Project Name / File No.: Brodie / PA22-023
Applicant: JM1 Holdings, LLC
Project Description: 45 Lot PRD-Subdivision
Re: Response to 2nd Review Comments

This letter serves as the Applicant's formal response to the 2nd review comments received on December 21st, 2022 to our recent application materials submitted to the City of Marysville. To ensure that each of the comments have been responded to, we have incorporated each of the City's comments along with the Applicant's response to each below.

PP-01
 SHEET 2 OF 3

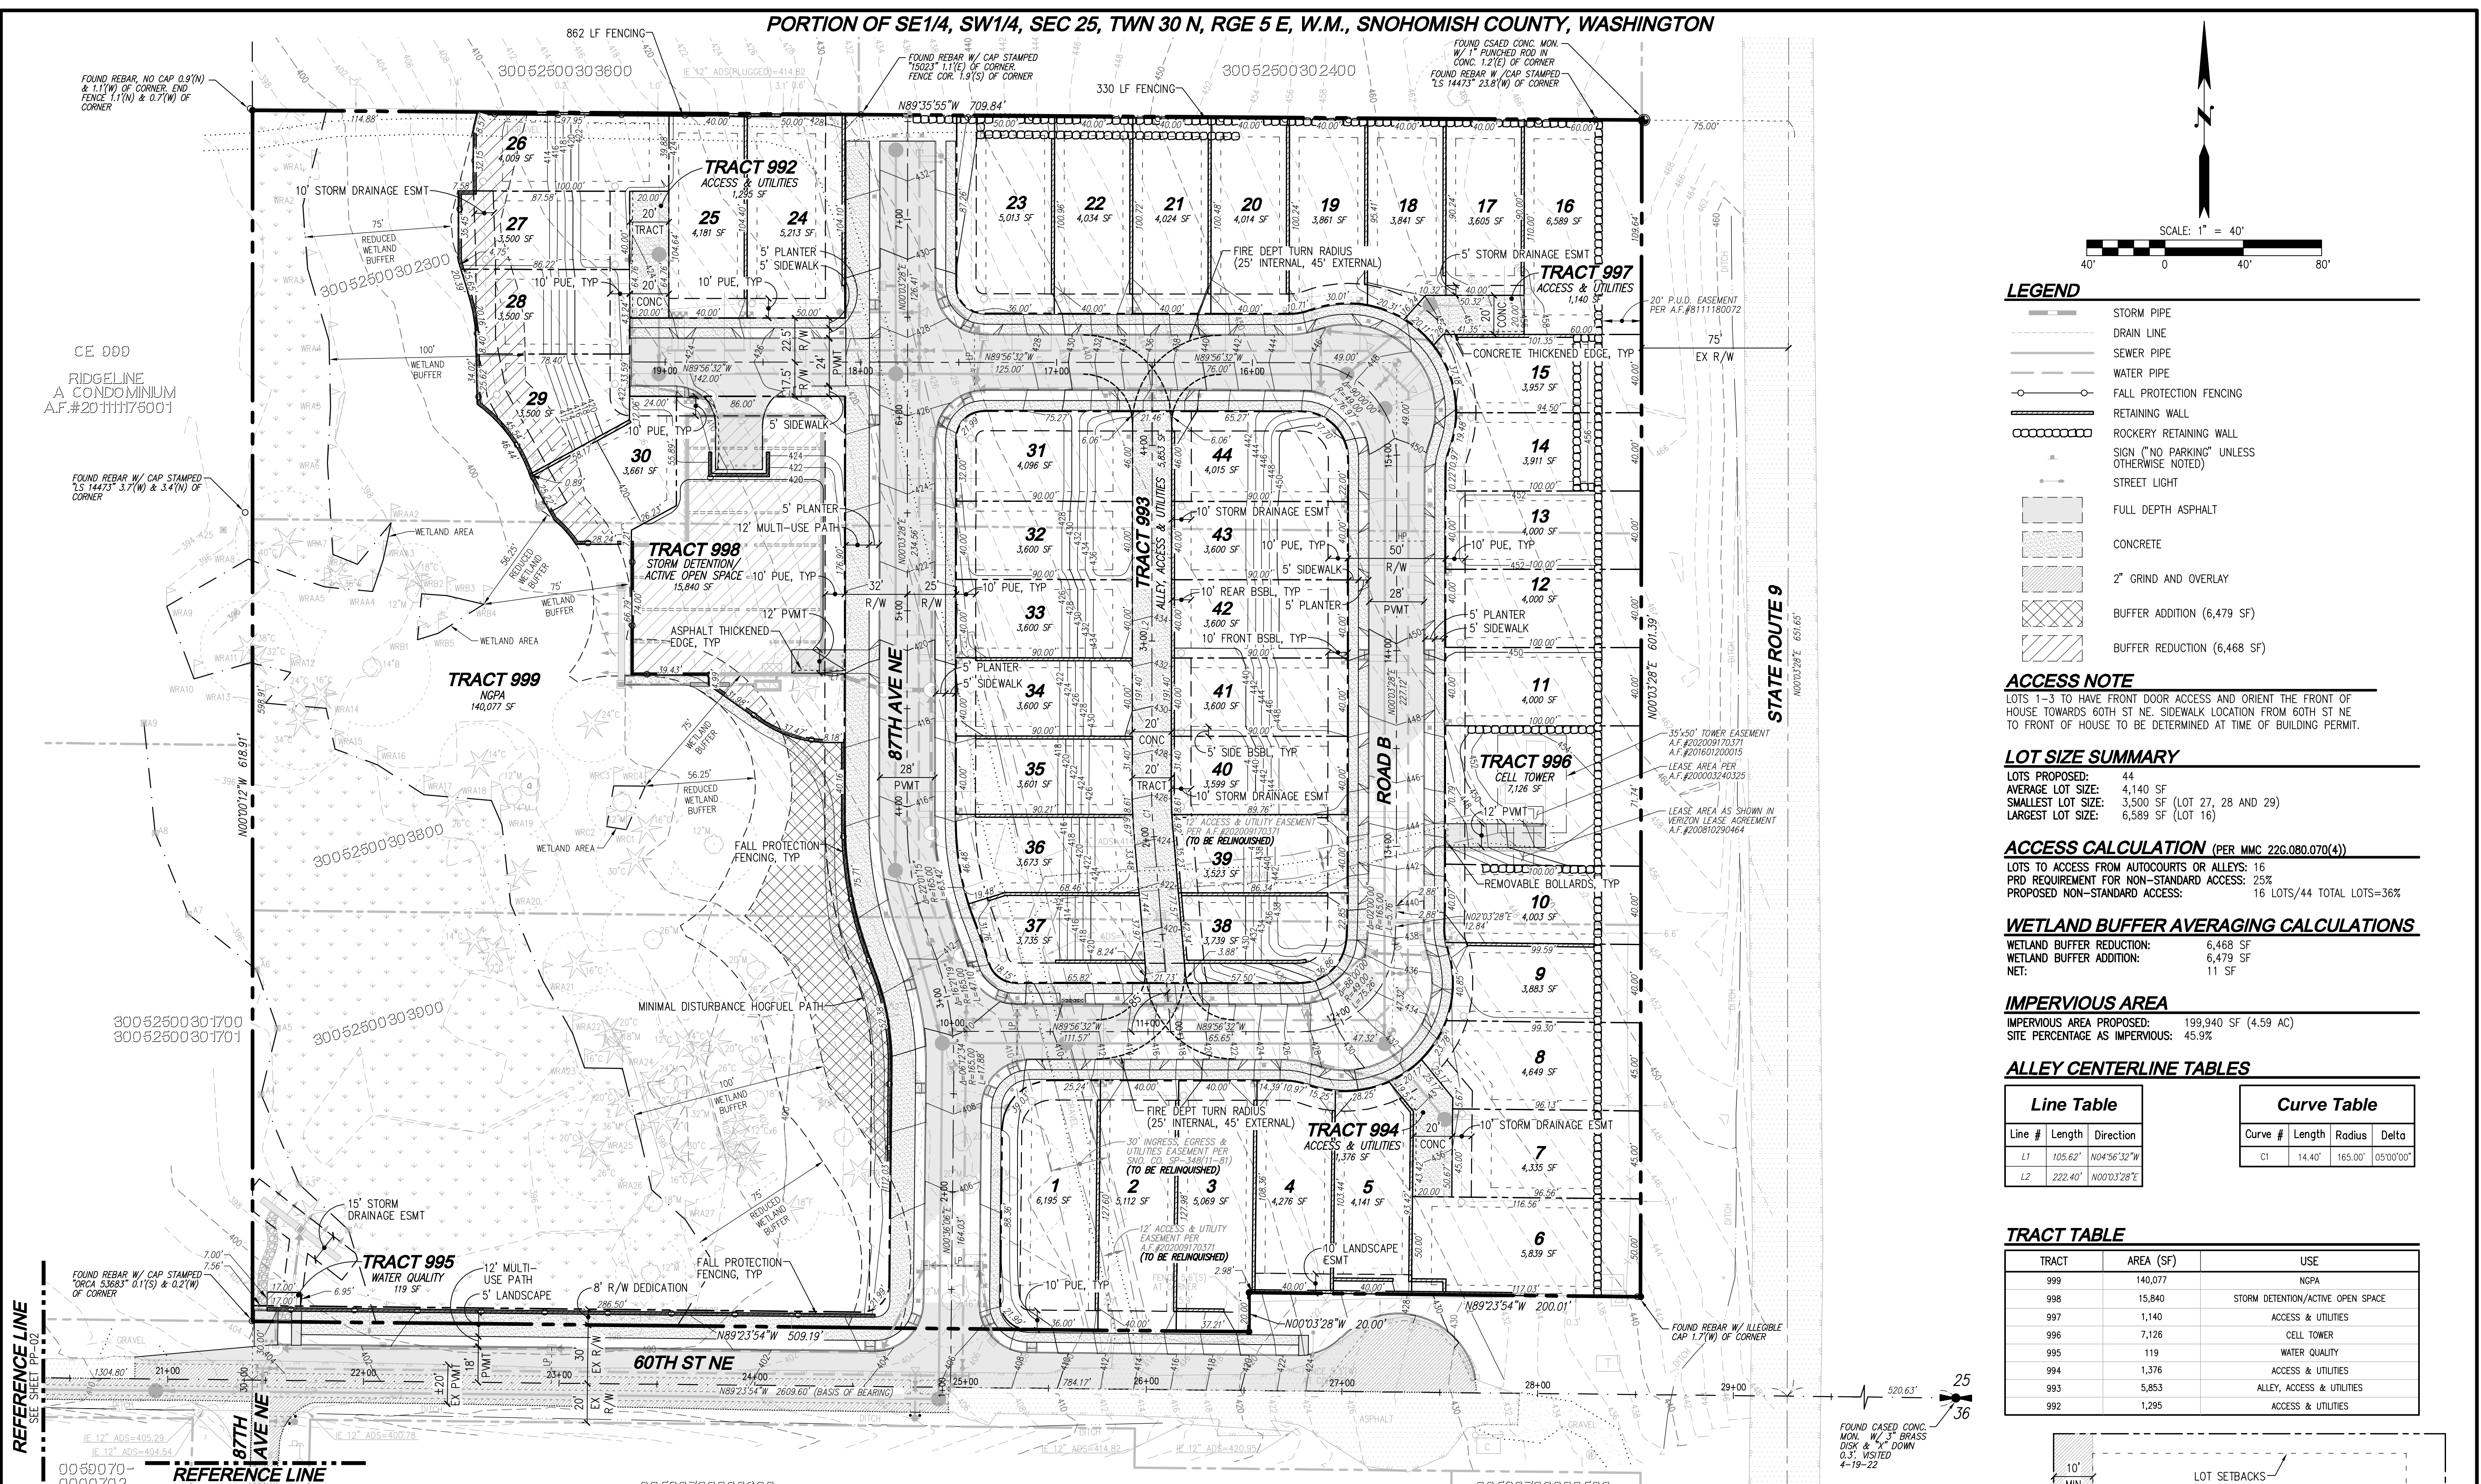
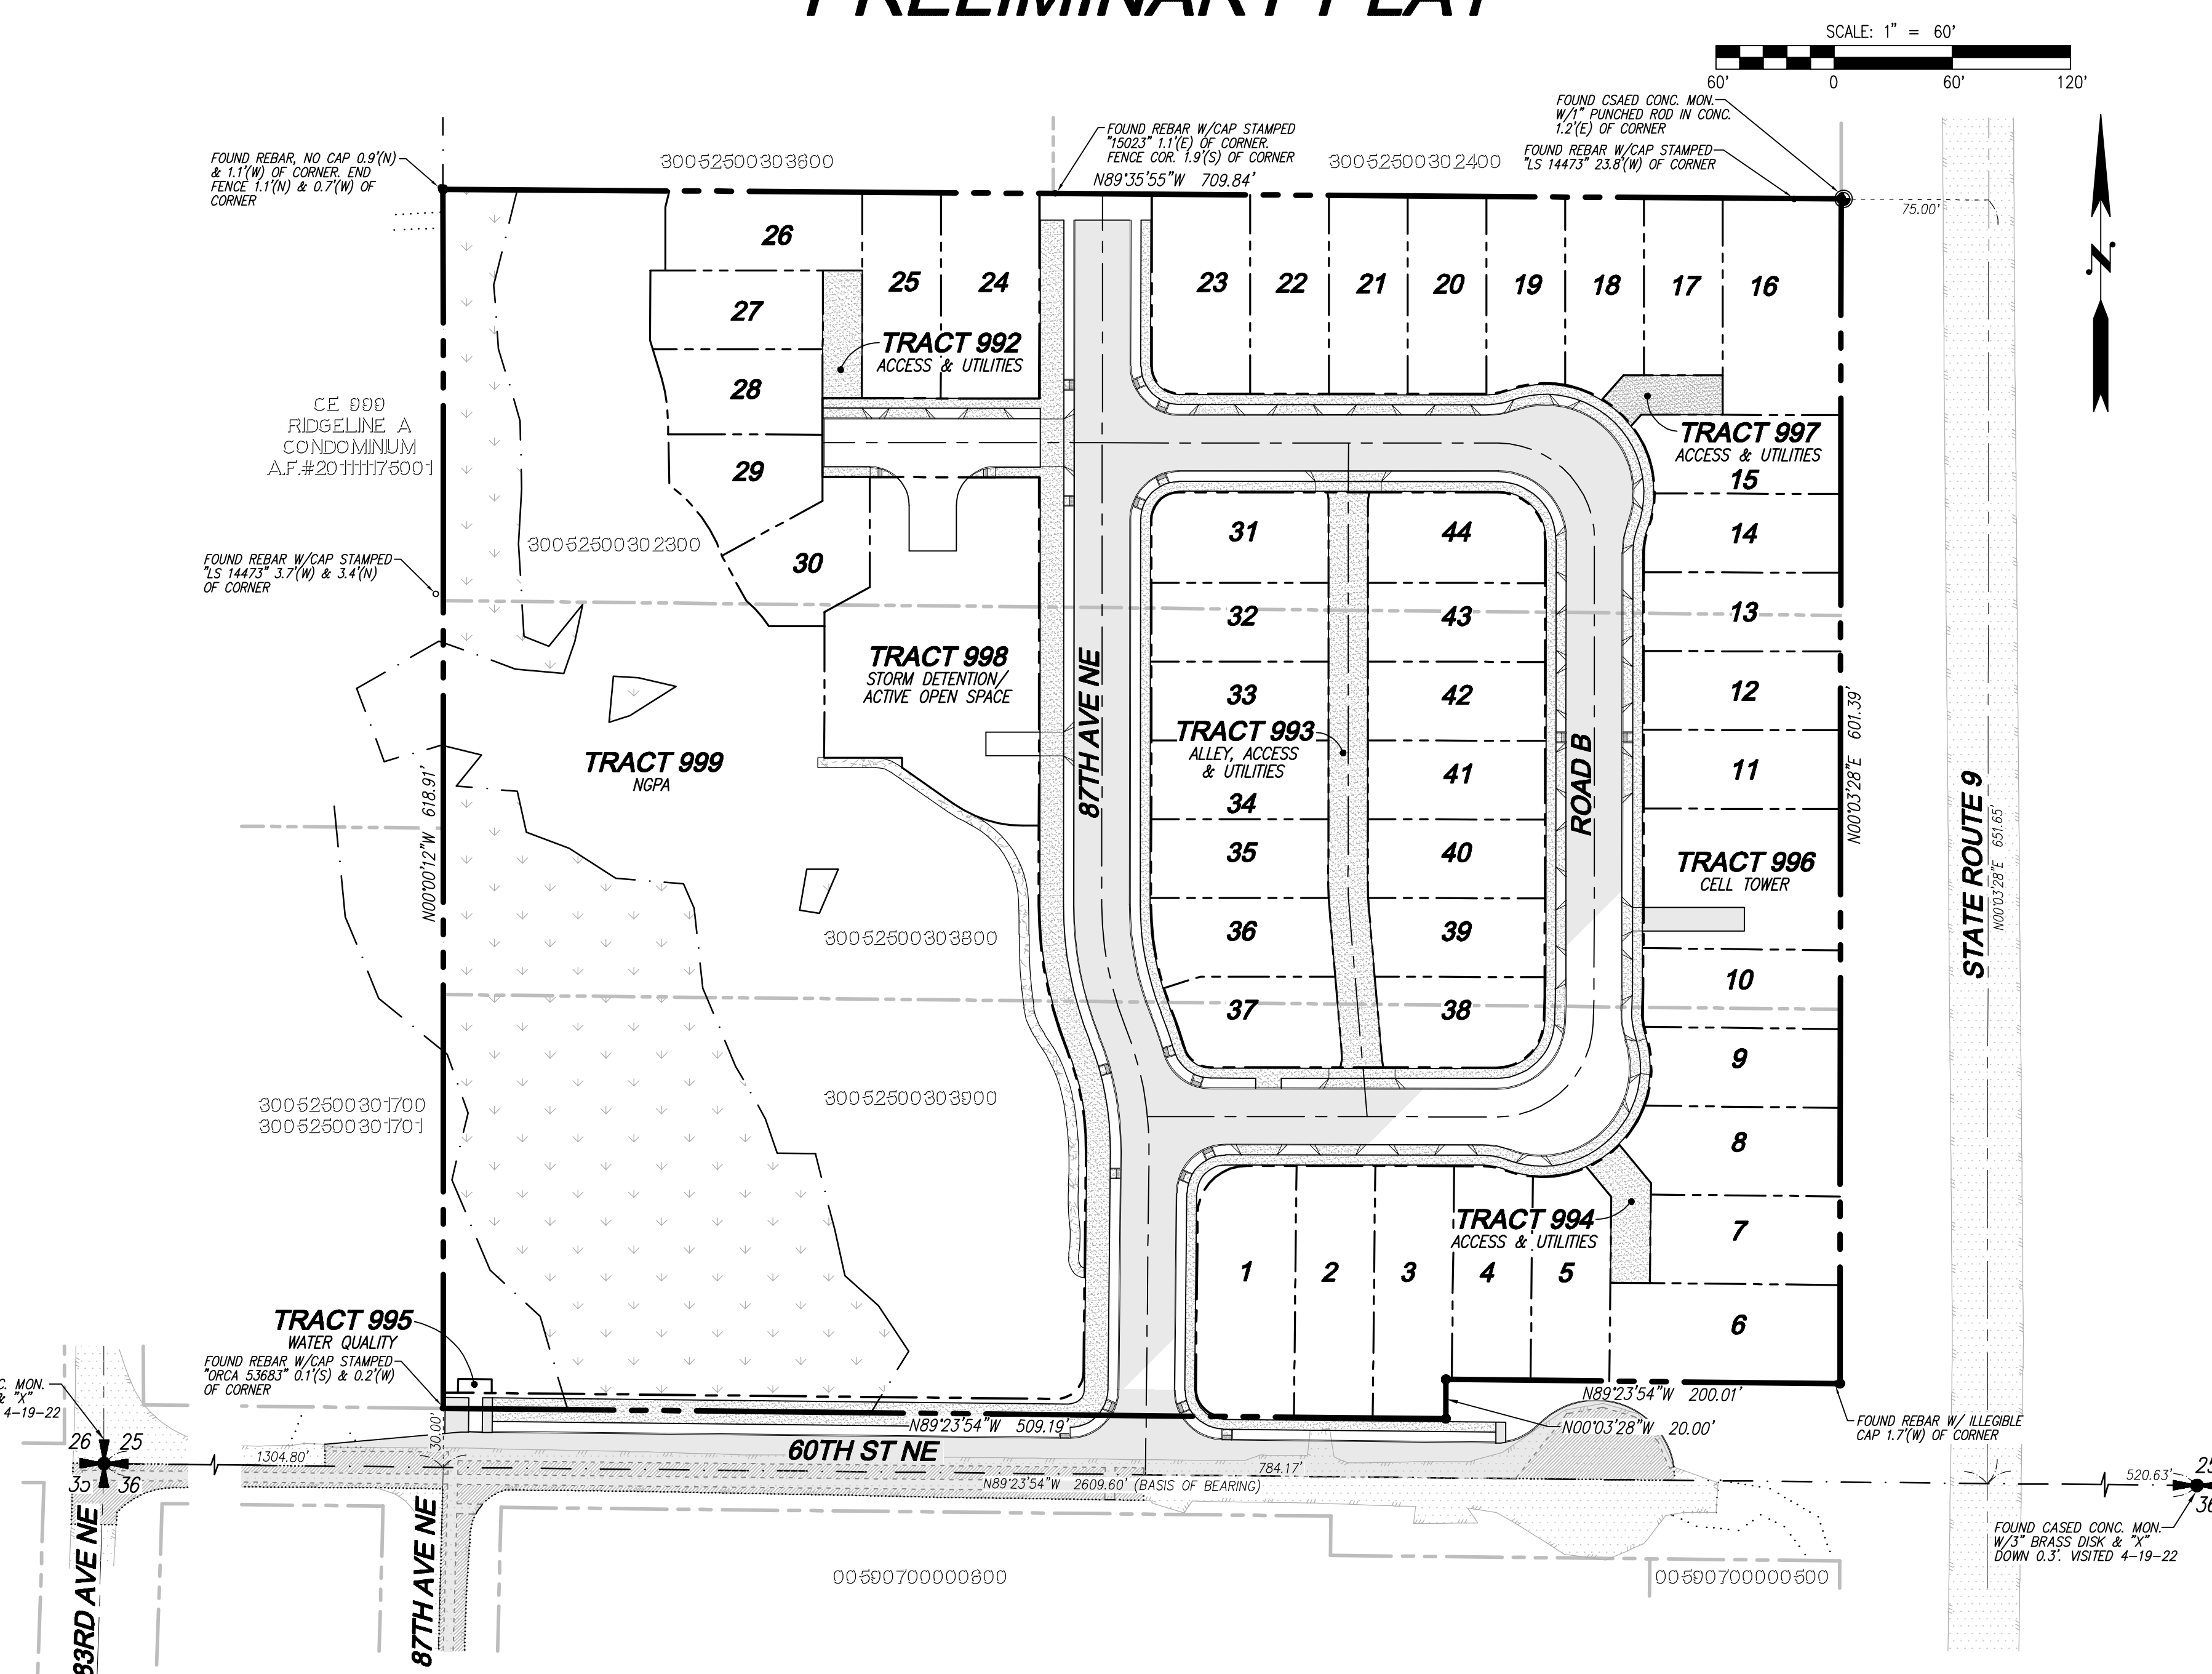
2. Comments received during the 1st round of review from Kacey Simon note that a full cul-de-sac is required at the eastern terminus, this would include full curb, gutter, and sidewalk. As noted in the resubmittal letter, no sidewalk if proposed and the north half of the cul-de-sac is not demonstrated in the provide plans; plans must be revised to satisfy these requirements.
Applicant's Response: Based upon further coordination with the City. The sidewalk as designed is acceptable. Additional grind and overlay of the northerly half of the cul de sac has been provided in the revised plans at the direction of the City.

3.2. Staff may be amenable to Lots 4 and 5 not being oriented toward 60th Street NE, however, a 10 ft. landscape easement with fencing, to be maintained by the HOA, would be required.
Applicant's Response: A 10' landscape easement with fencing has been proposed

4. Based on Sheet GR-01, some of the sections of the proposed retaining wall will exceed 4 ft. in height and are positioned along the right of way. Being as there are residences across 60th St NE, the wall sections exceeding 4 ft. are required to be terraced.

along the rear of lots 4 & 5. HOA maintenance requirements can be described on the Final Plat. Lots 1-3 will remain in their current orientation. A note has been added to the Preliminary Plat that notes that Lots 1-3 will take front door access from the 60th St NE ROW.

Applicant's Response: Revisions to grading and additional tiering of walls along the rear of lot 5 and the side of Lot 6 make a maximum wall height of 4'.

DRAWING NO.:	IL-01																																		
SHEET NO.:	1																																		
OF	3																																		
SHEETS

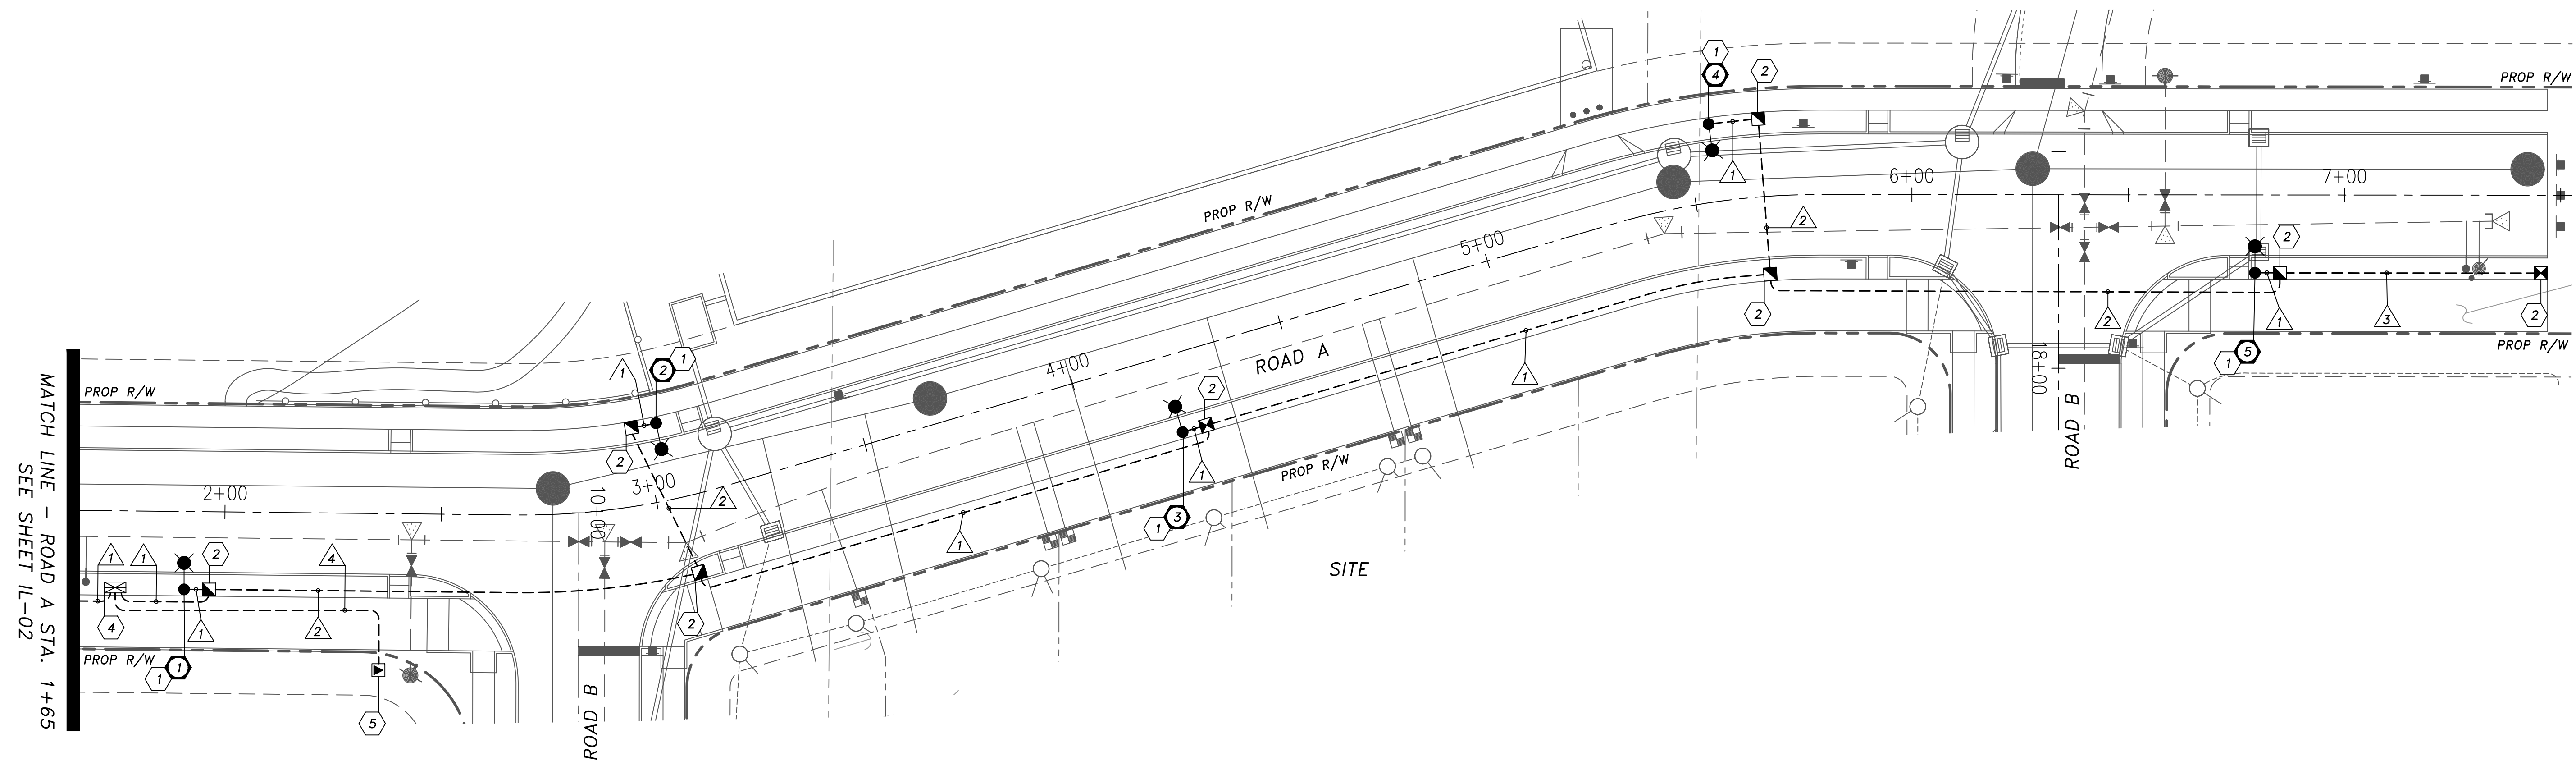
- i. WSDOT Type D Service Cabinet shall be per City Special Provision with height of 46".
Applicant's Response: Acknowledged. A note will be added to the decorative street lighting plan and resubmitted with the revised civil plans.
